Response to Planning Application

From: Arun District Council Greenspace

Application ref: AL/79/20/OUT

Location: Land to West of Hook Lane Hook Lane Westergate PO20 3TE

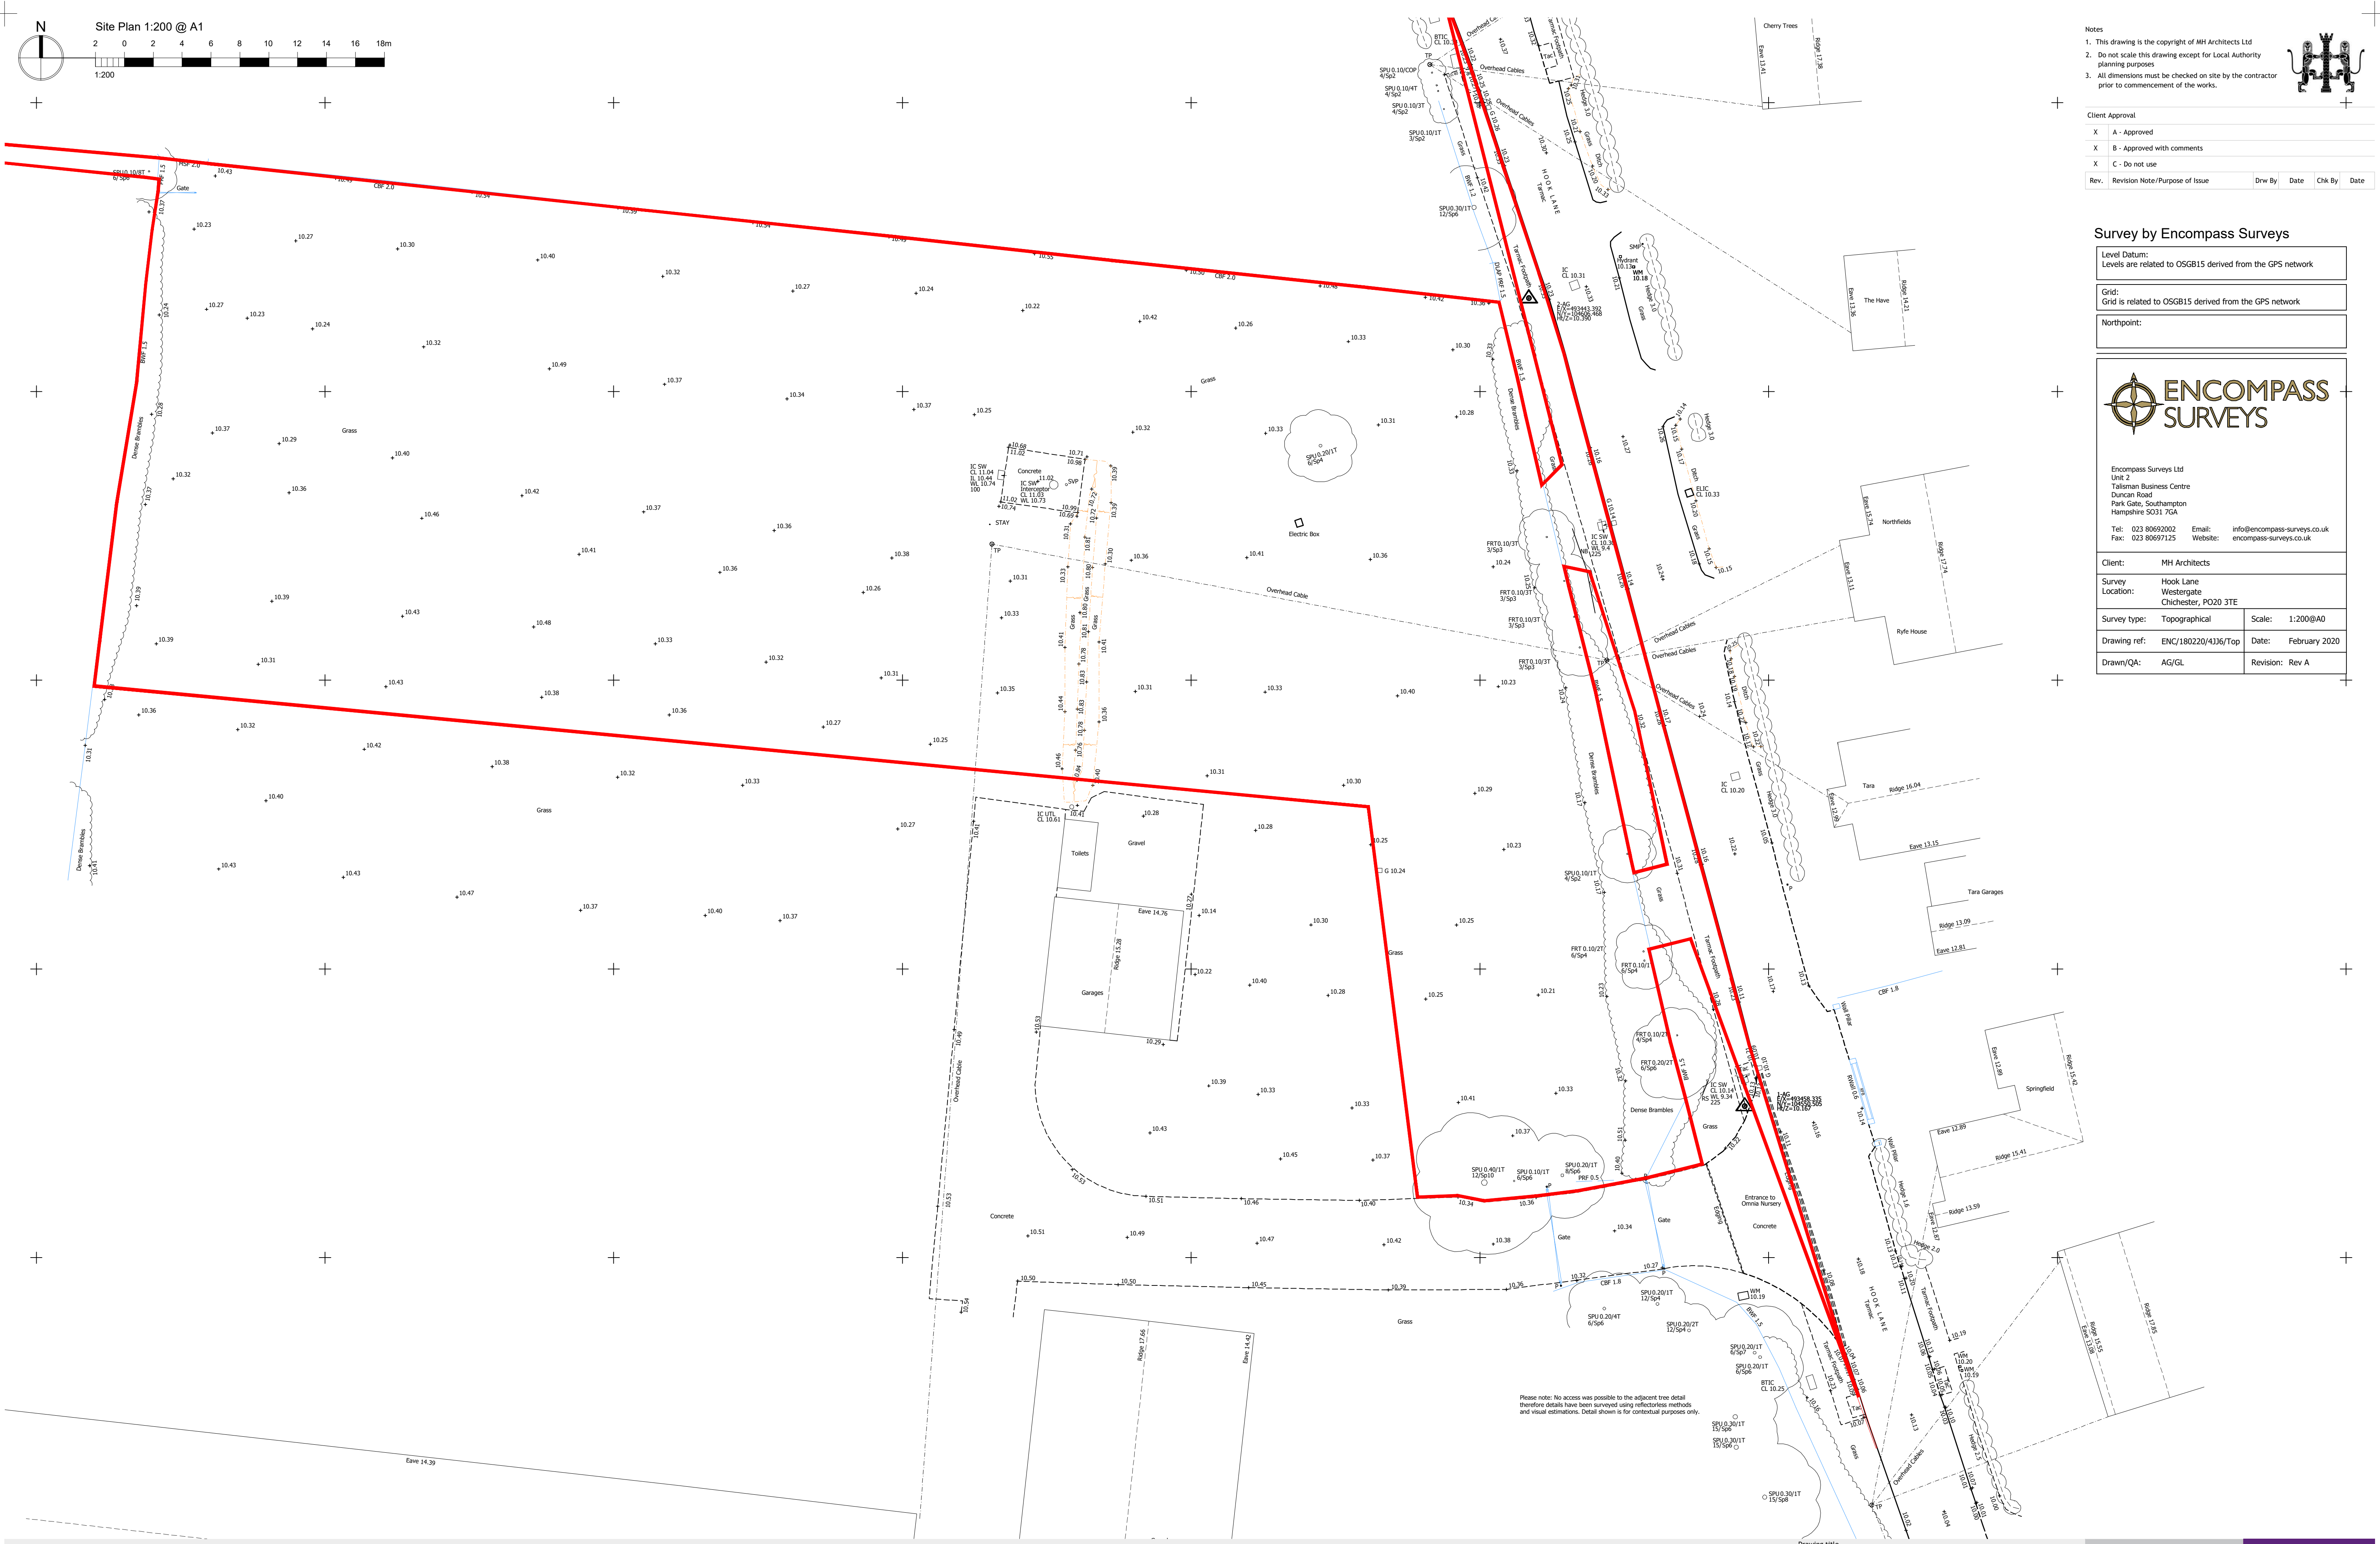
Further landscape provision to the roadway and accessible areas and incorporation of screening to adjacent properties with the incorporation of planted areas for trees and shrubs would be required. The green boundary treatment should allow a buffer area to enhance and improve the existing and include tree species. All areas should be considered and their connection for biodiversity and habitat explored. Trees specified should be at a size which allow instant impact, but which will establish and mature as the site develops.

The illustrative Site Plan Dwg No 19-191 HKL MHA 00 XX DR A 0003 Rev P05 shows indicative landscape proposals which would need to be confirmed in plan form to show existing to be retained and new planting detailing species choice, actual quantities, planting densities and size at time of planting.
